Your Ref: 2019/90085
Our Ref: V001198

Land at Lancaster Lane, Brockholes, Holmfirth - Erection of 10 dwellings

DRAWN: JF	DATE: DEC '18
CHECKED: JC	SCALE: 1:200 @
DRAWING NUMBER:	2534 - 03

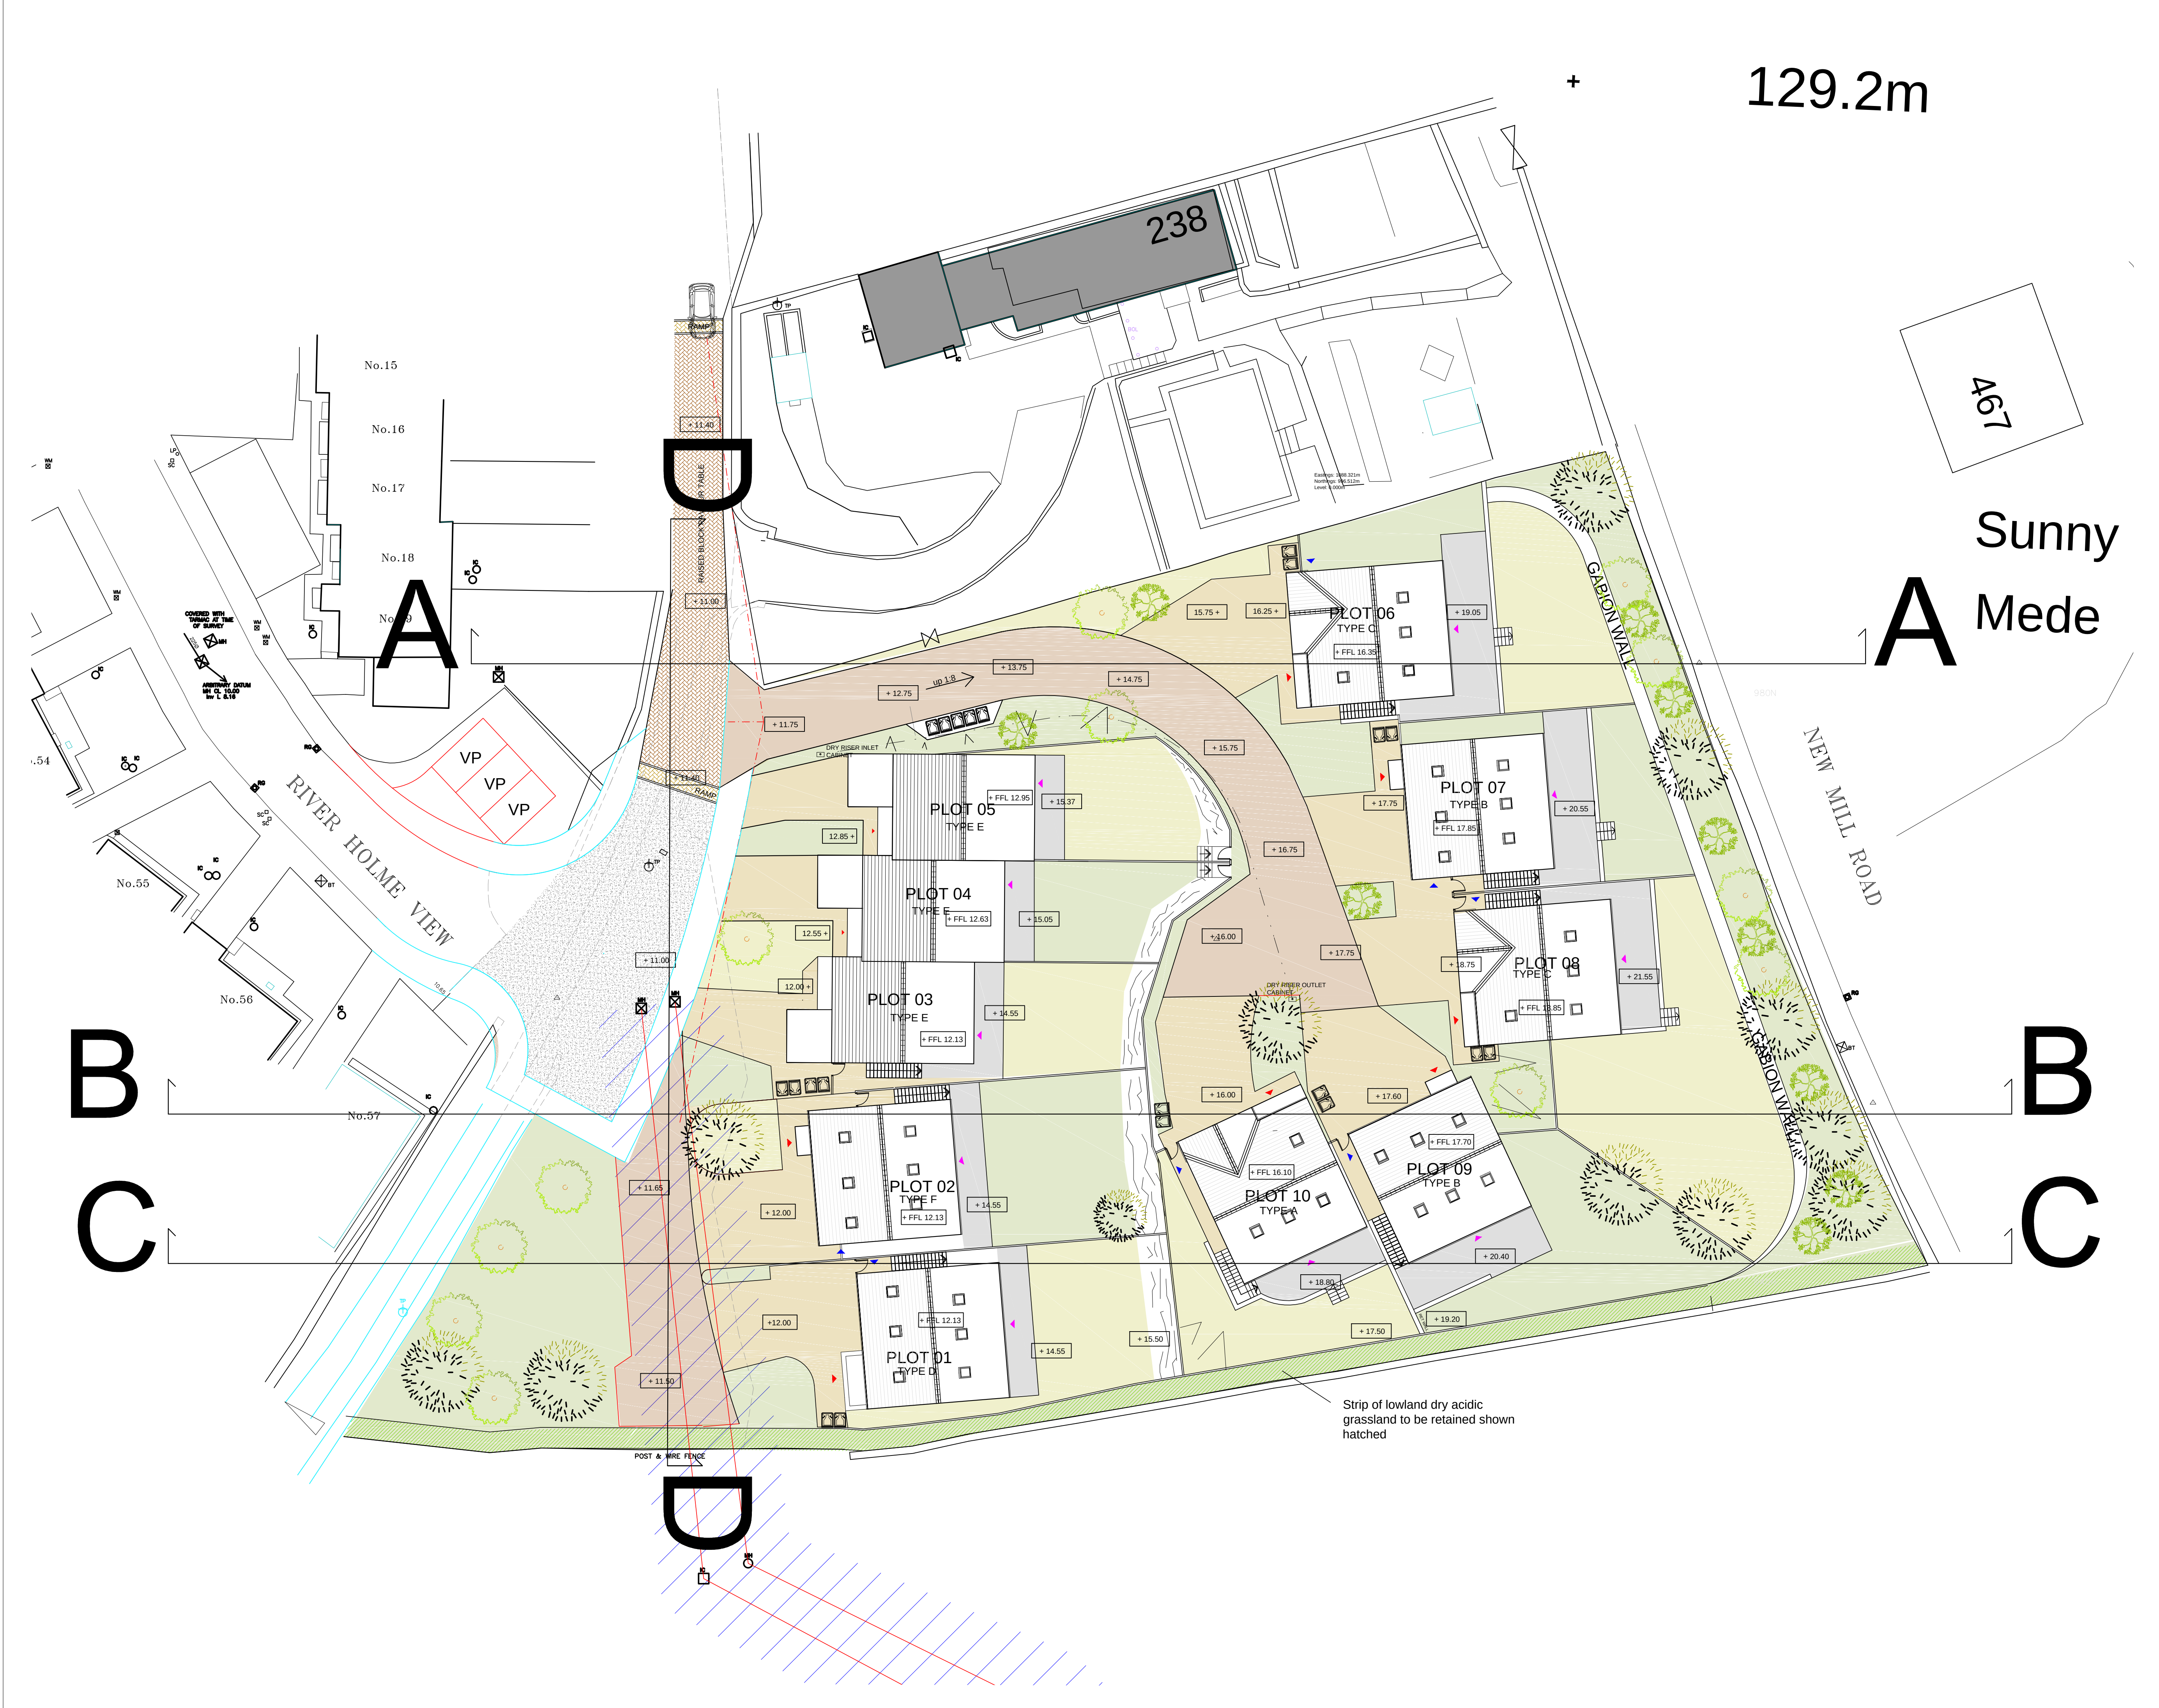
A 90mm live water main is included within the redline boundary and the sites access route appears to be located over it. The pipe must be protected during construction of the development or it may be possible to divert it.

1) On the Statutory Sewer Map, there is a 375mm diameter combined public sewer and a 450mm diameter combined public sewer recorded to cross the site. It is essential that the presence of this infrastructure is taken into account in the design of the scheme. The landscaping details submitted on drawing 2534-03 dated December 2018 prepared by Acument Designers & Architects require amending as it appears that a tree is proposed to be planted within the required stand-off distance of the line of public sewer crossing the site. **For further information , the developer should contact our Developer Services Team (telephone 0345 120 84 82 (Option 1), technical.sewerage@yorkshirewater.co.uk**
